A46 Coventry Junctions (Walsgrave) Scheme Number: TR010066

8.16 Applicant's Comments on Submissions Received at Deadline 1

**APPLICANT'S COMMENTS ON SUBMISSIONS
RECEIVED AT DEADLINE 1**

Rule Number	Rule 17(1)
Planning Inspectorate Scheme Reference	TR010066
Application Document Reference	TR010066/EXAM/8.16
Author	A46 Coventry Junctions (Walsgrave) Project Team, National Highways

- E2.1 DRAINAGE FEATURE REFER TO DRAINAGE DESIGN

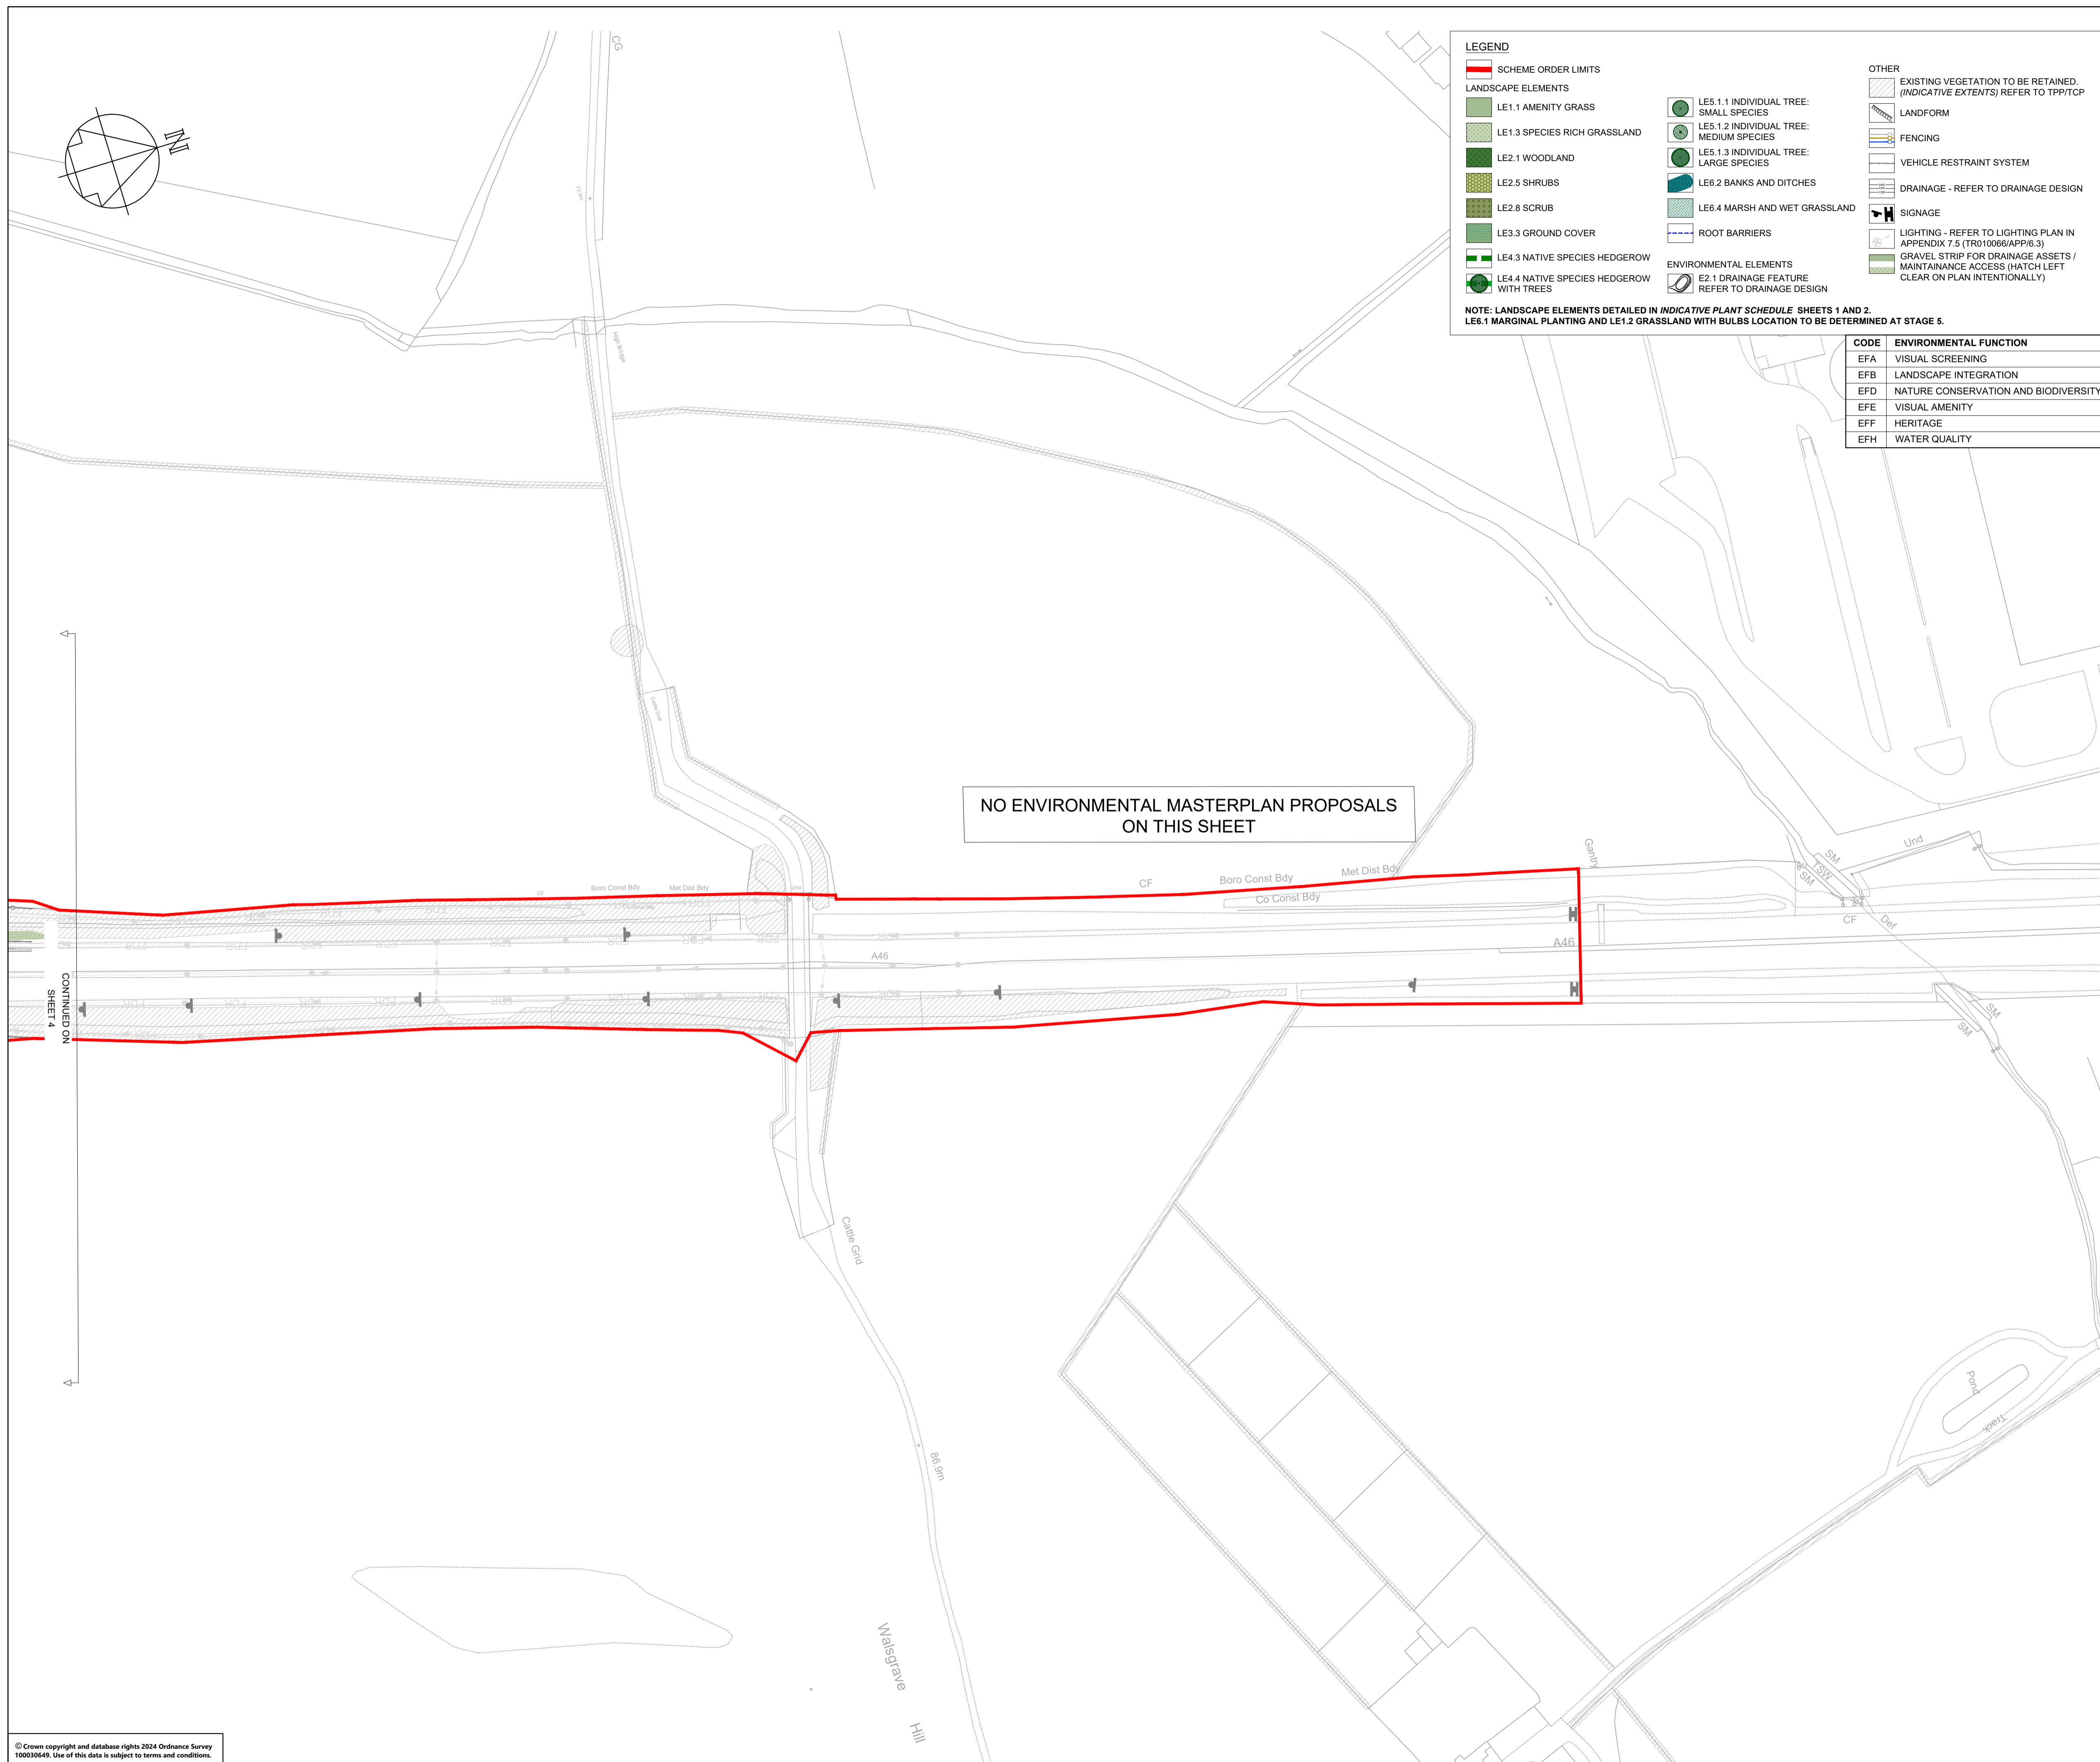
AP10 bullet 2	<p><i>Action - What is the Environment Agency's position on the Applicant's proposals to protect and enhance watercourses and the development of new habitats in proposed detention basin?</i></p> <p>The Environment Agency (EA) approves of the proposed measures outlined in Figure 2.4, to plant scrub, hedgerows and woodland around the new detention basin, to improve connectivity between the waterbody and the surrounding landscape. We also approve of the native seed and plug mixes chosen to enhance the basin (LE6.4, page 12) and to enhance the riparian edges of the watercourses (LE6.2, page 12). However, we would also recommend adding rushes (e.g. <i>Juncus</i> sp.) to the species lists.</p> <p>In addition, further enhancements measures could be considered to make the detention basin and watercourses more attractive to wildlife by providing habitat variety if possible and practicable.</p>	<p>The Applicant will consider the Environment Agency's recommendation to include rushes (e.g., <i>Juncus</i> sp.) in the species lists LE6.2 and LE6.4. This will be done in collaboration with the Scheme ecologists and drainage experts to determine their practicable inclusion. Additionally, the Applicant will explore further enhancements to the detention basin and watercourses during the detailed design stage, continuing to work closely with the Environment Agency to assess what is feasible and practical.</p>
